**A-1 CHIPSEAL**  
GRADING AND EROSION CONTROL PLAN  
**PROPOSED SAND FILTER**  
MAY 2022

A-1 CHIPSEAL	GRADING AND EROSION CONTROL PLAN PROPOSED SAND FILTER
--------------	--

DESIGNED BY	DLF
DRAWN BY	DLF
CHECKED BY	LD
H-SCALE	AS SHOWN
V-SCALE	N/A
JOB NO.	2173.00
DATE ISSUED	05/02/2011
SHEET NO.	3 OF 5

GRADING AND EROSION CONTROL PLAN
PROPOSED SAND FILTER

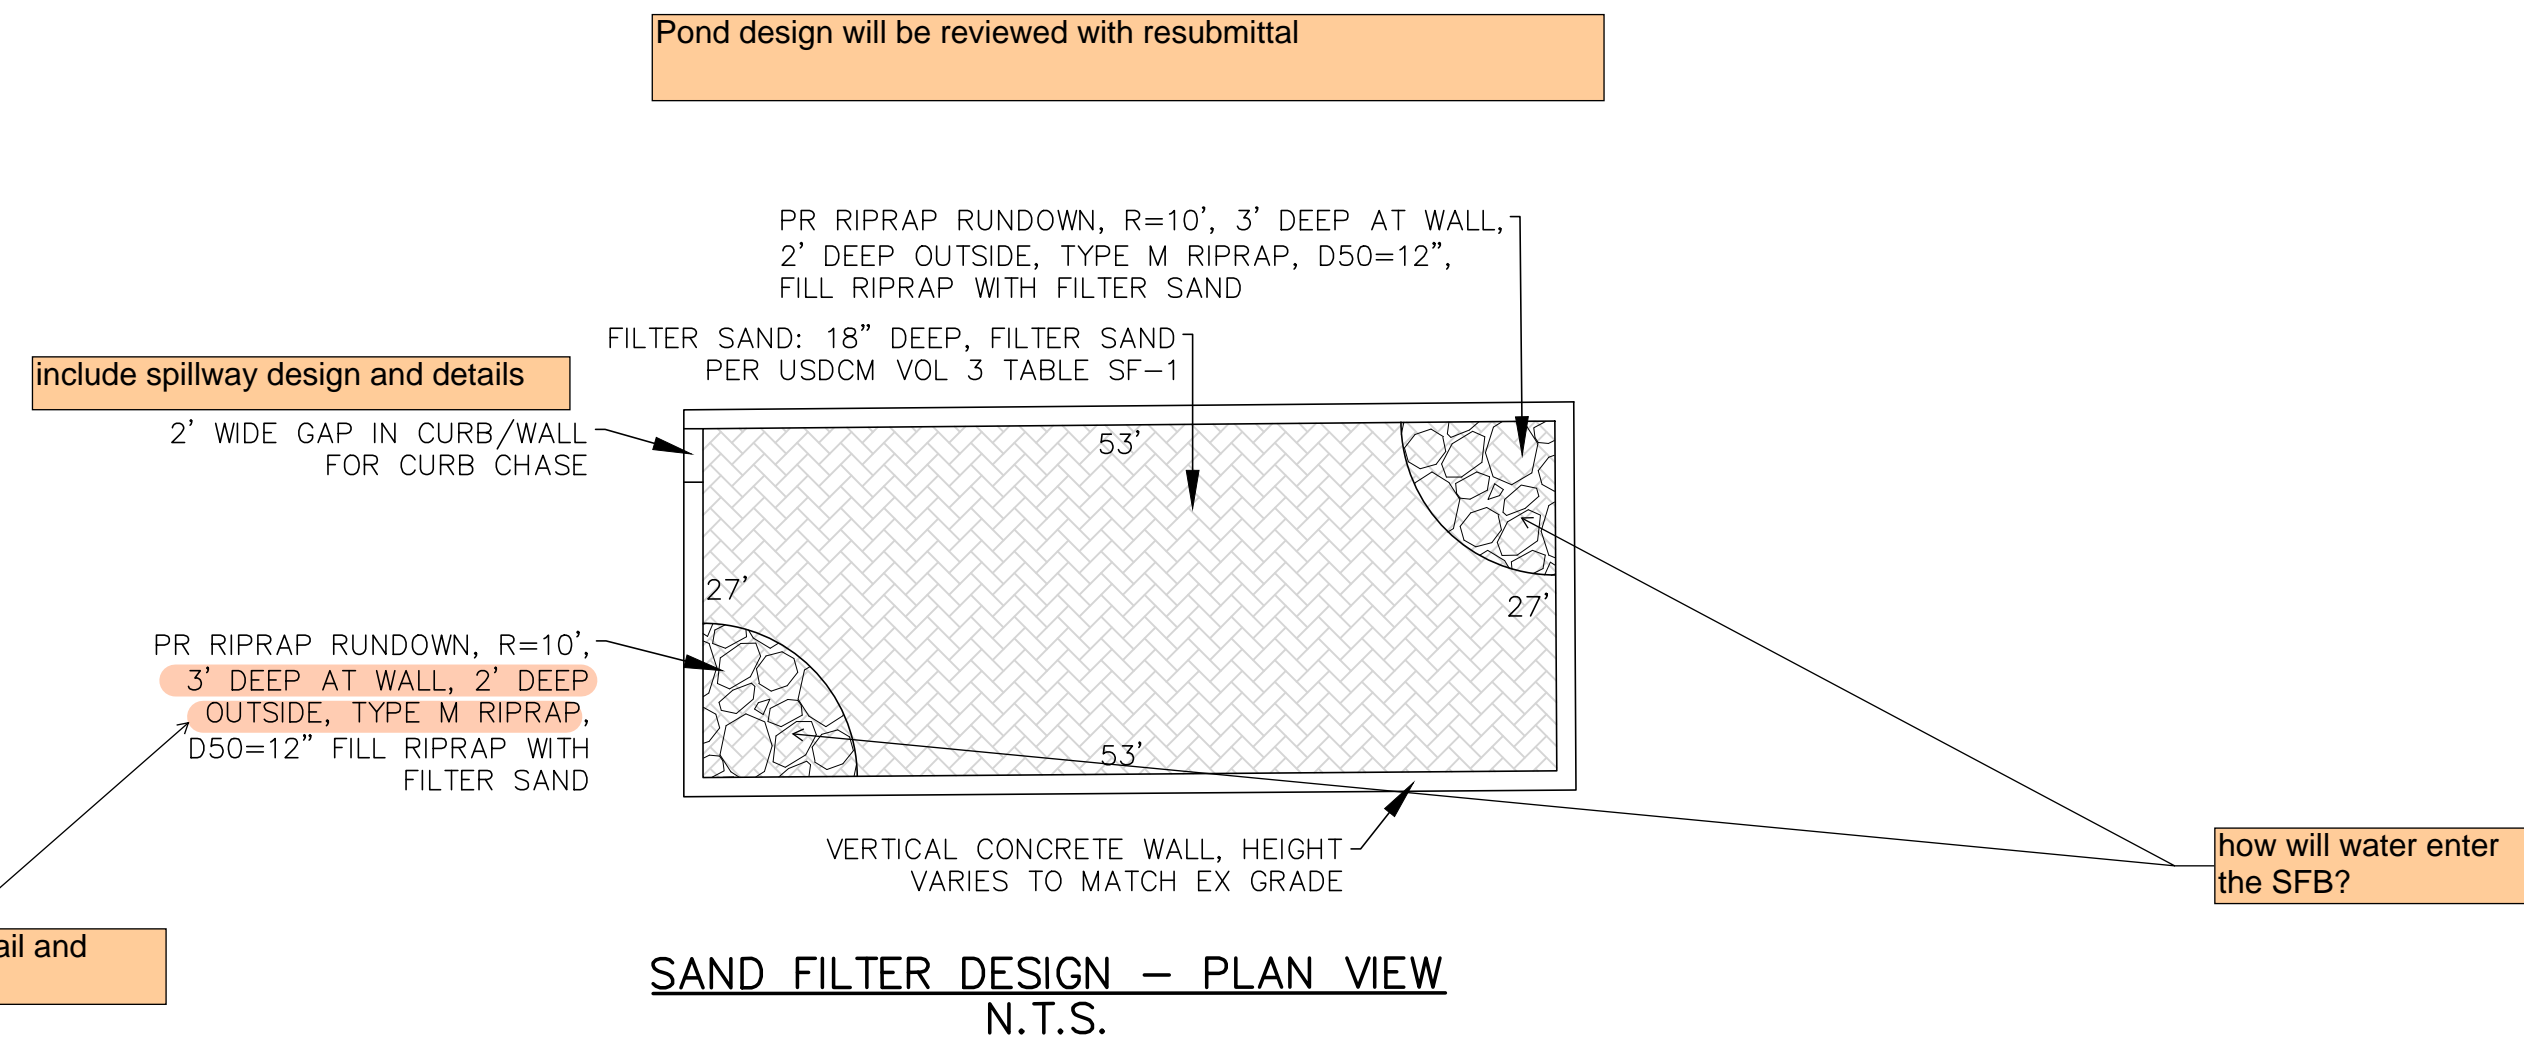
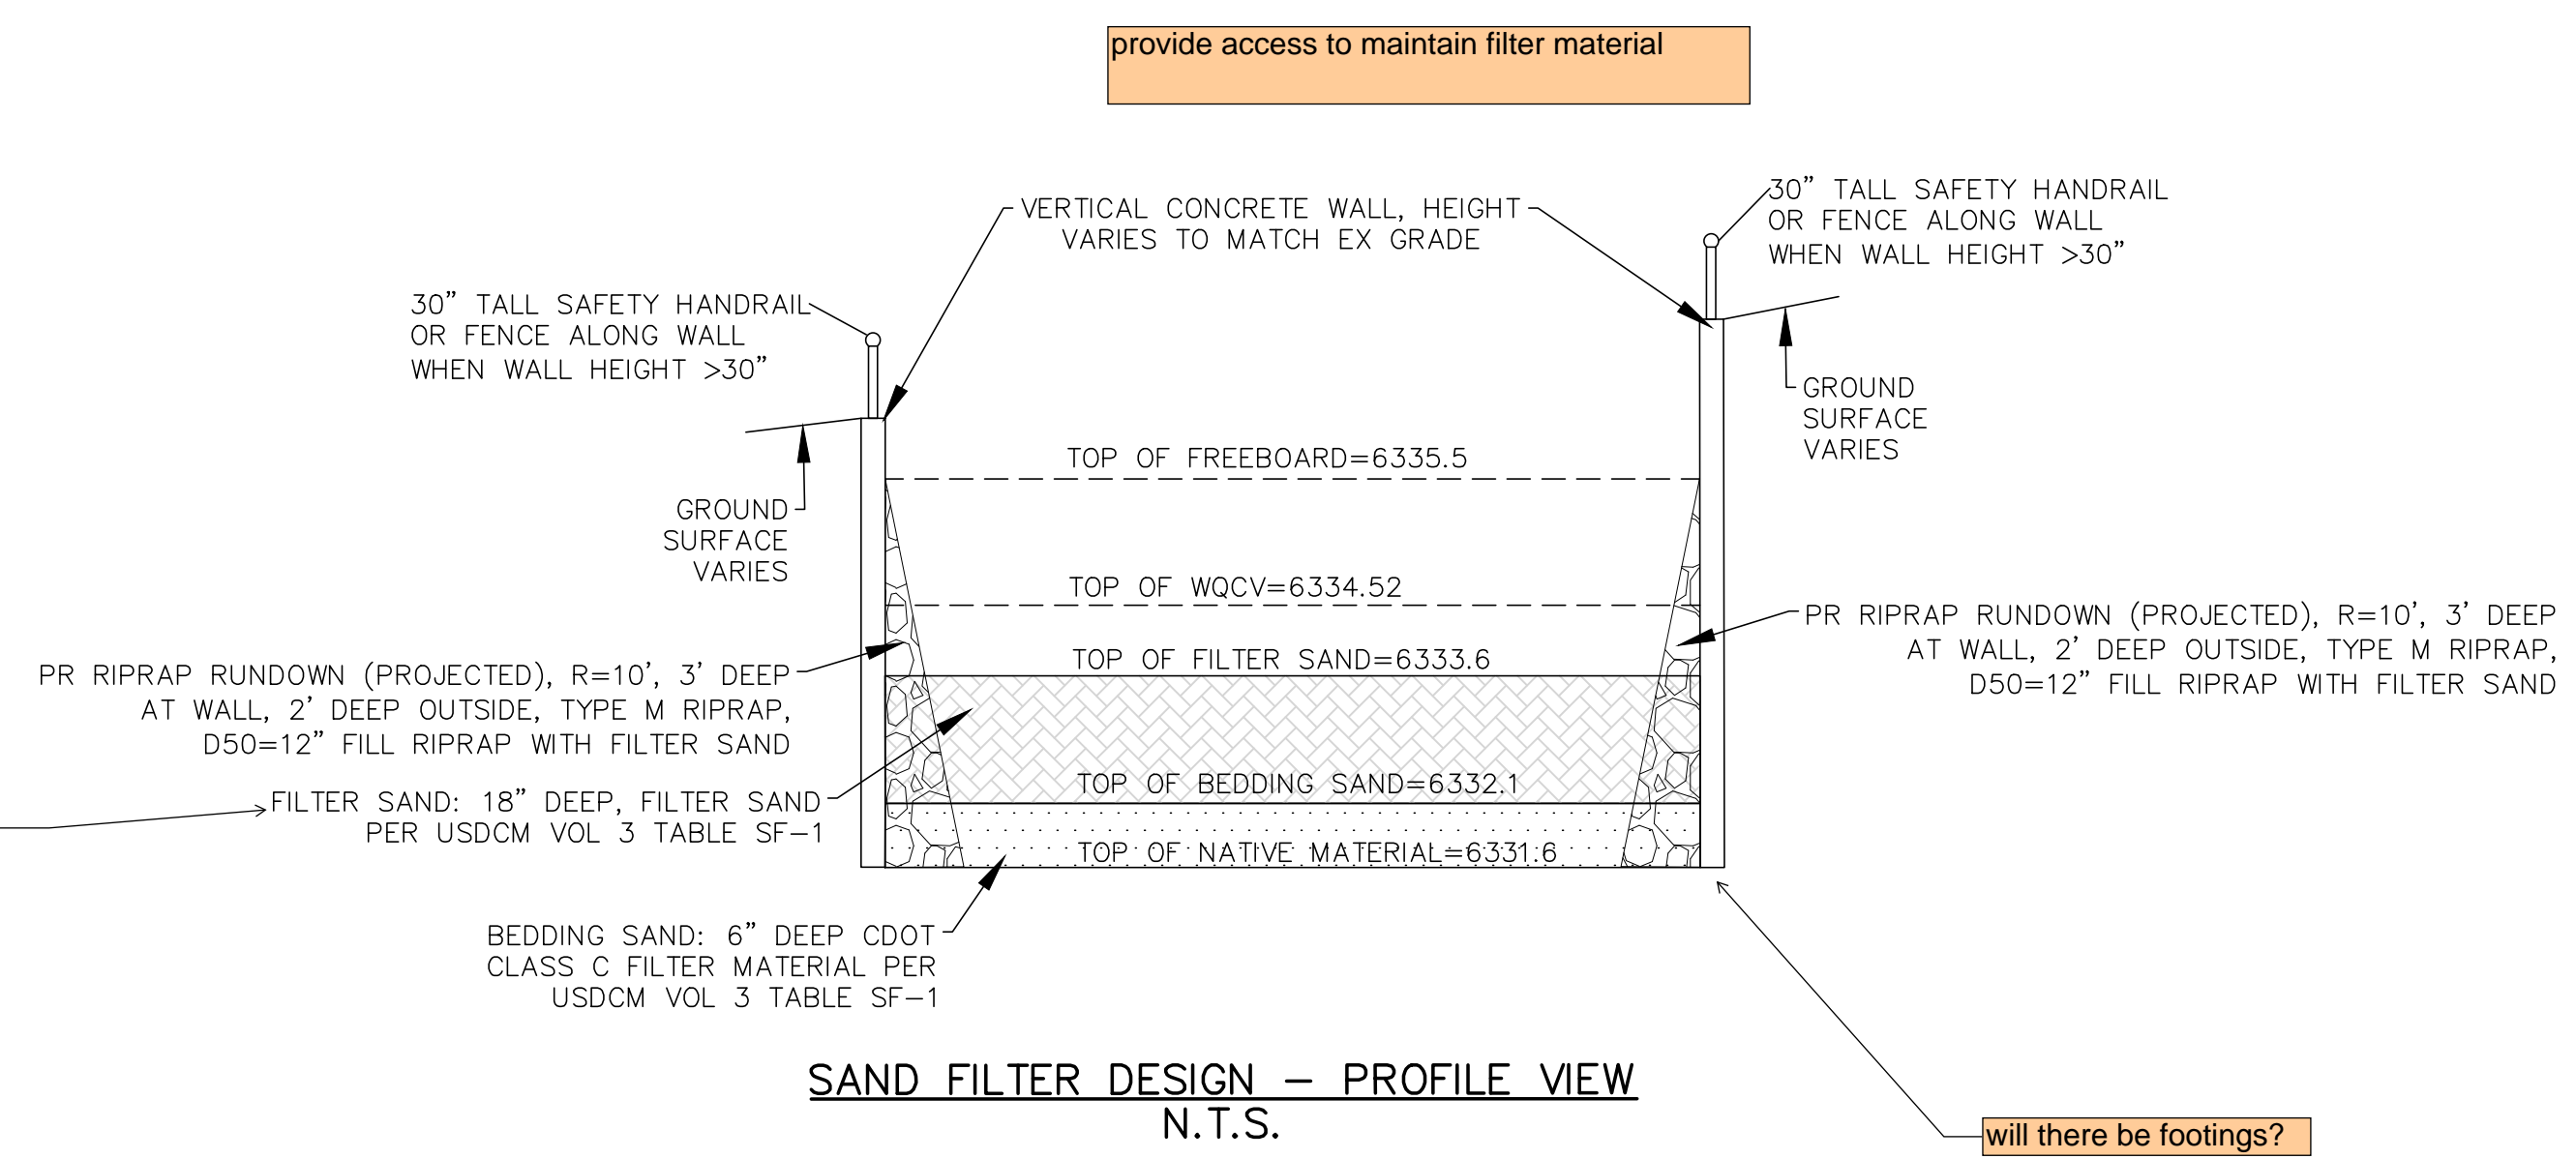
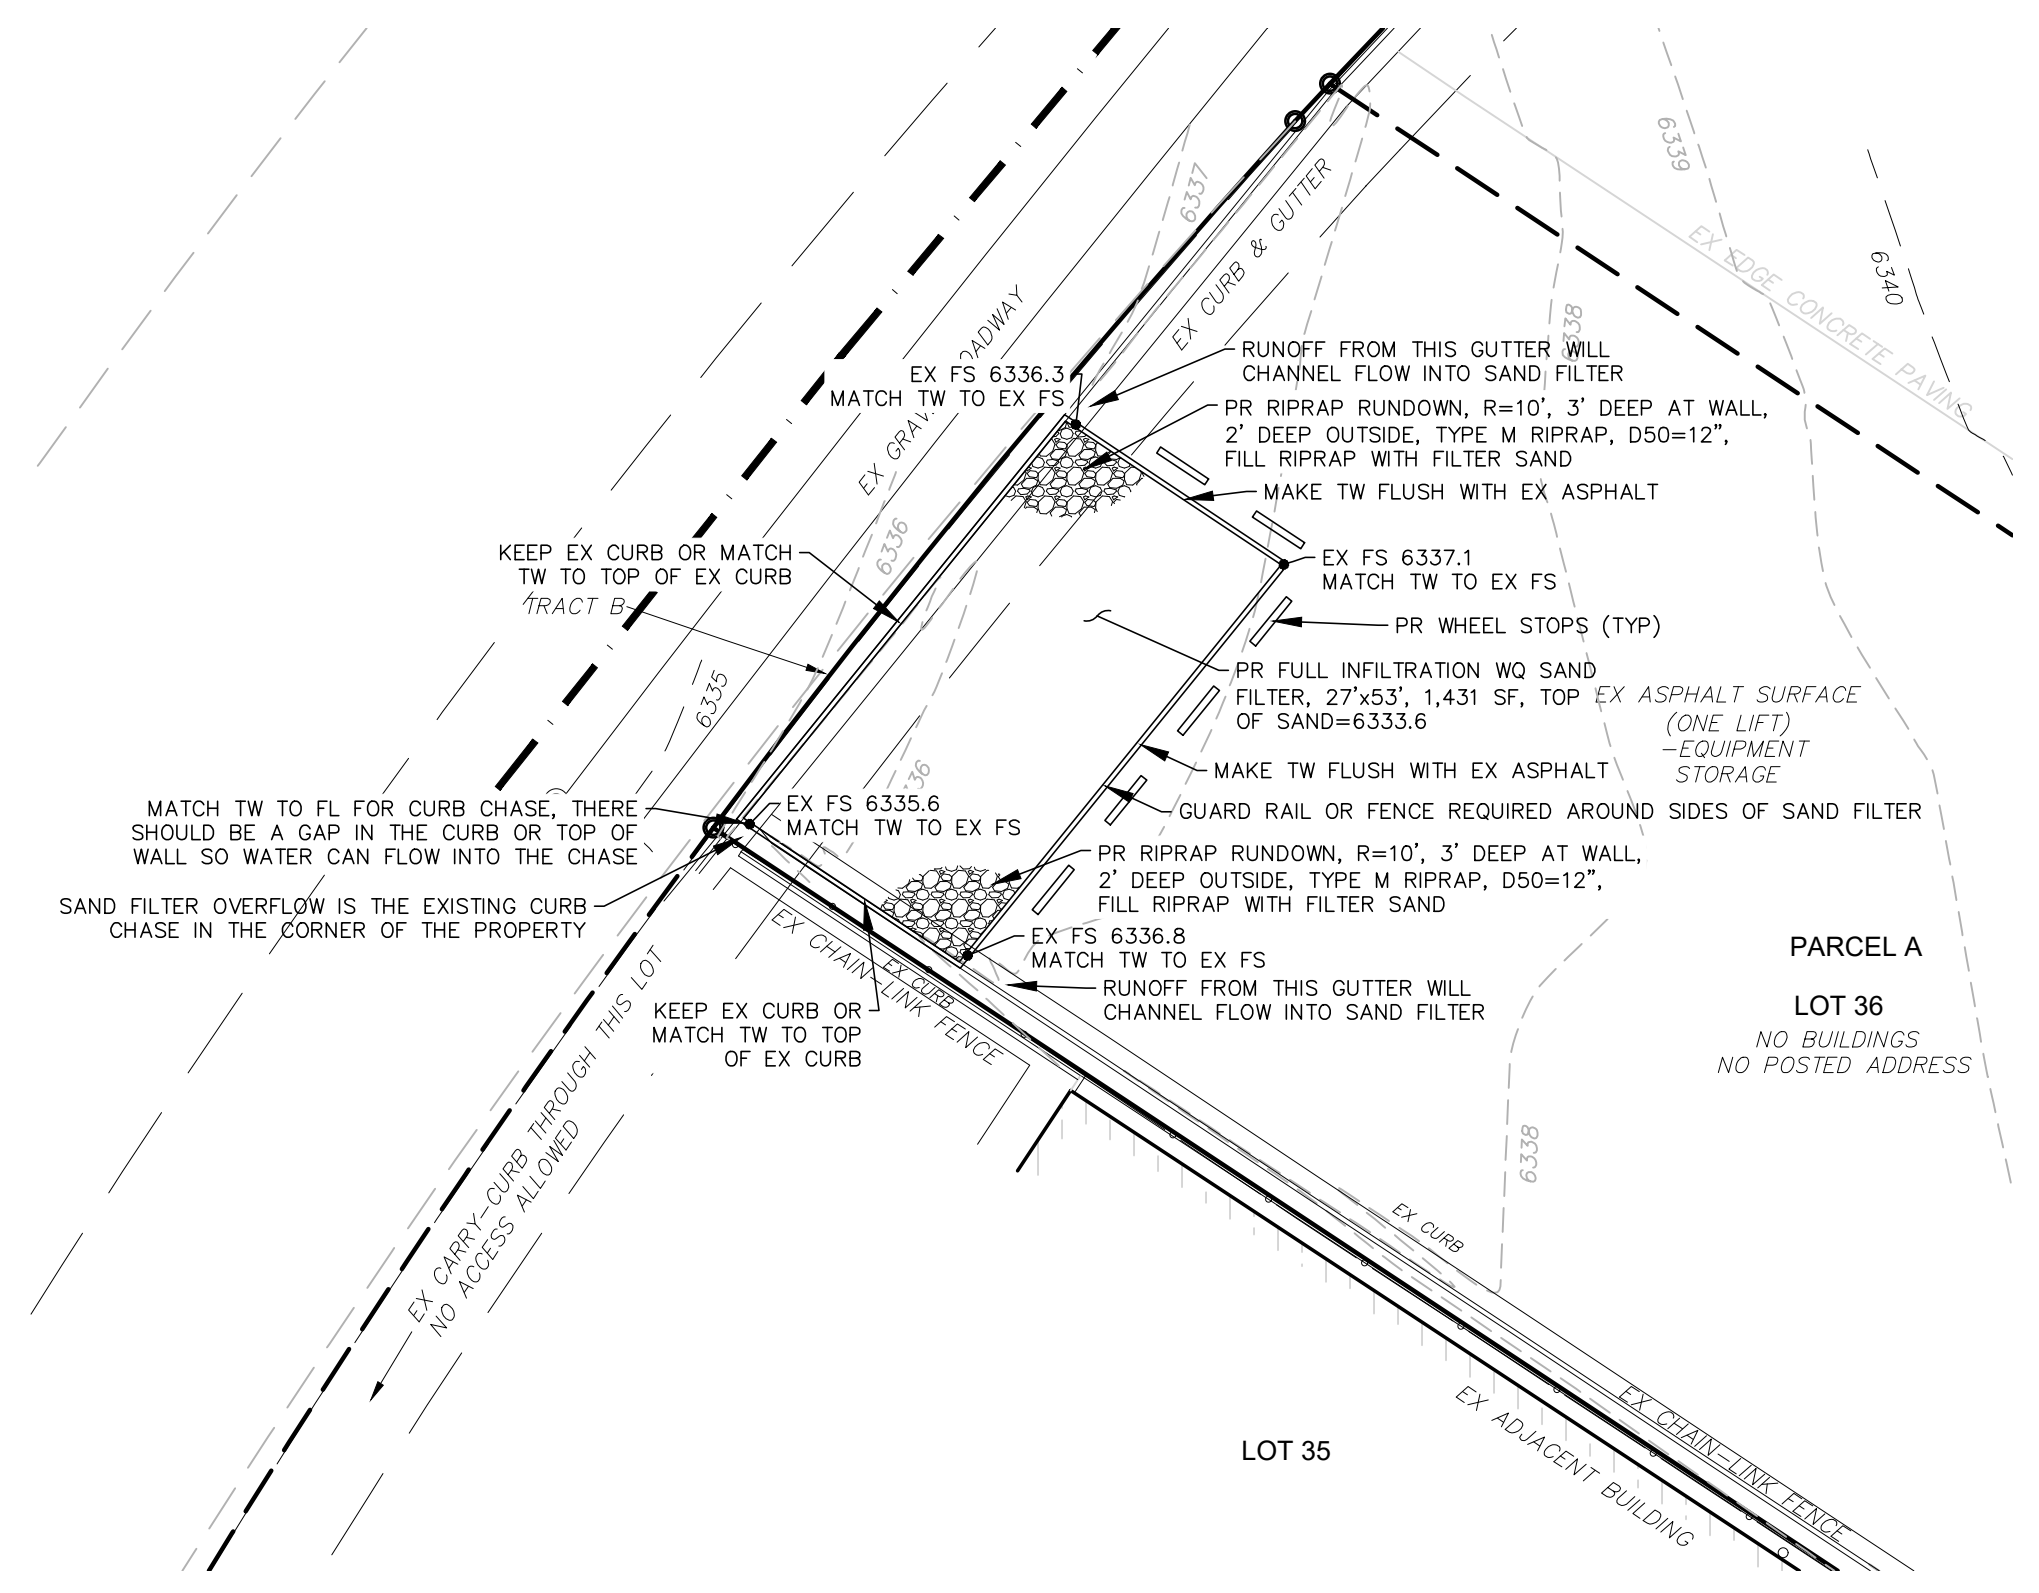
An on-site infiltration test using double-ring infiltrometer is required. Infiltration tests should be performed or supervised by a licensed professional engineer and conducted at a minimum depth equal to the bottom of the sand filter. Underdrains are required for sand filters and should be provided if infiltration tests show rates slower than 2 times that required to drain the WQCV over 12 hours

provide detail and show slope

Pond design will be reviewed with resubmittal

include spillway design and details

how will water enter the SFB?

provide access to maintain filter material

Specify whether Class B or C?

will there be footings?

Newly attached infiltration test shows that test used a double-ring infiltrometer, was signed by a licensed professional engineer, and was conducted 7 feet below the bottom of the sand filter.

Slope is now provided. Details are given on this page.

The spillway is the existing curb chase in the western corner of the sand filter as shown.

Existing curb and gutter directs flows to sand filter at these locations. This is the natural low point of site.

Footings will likely not be used for these walls.
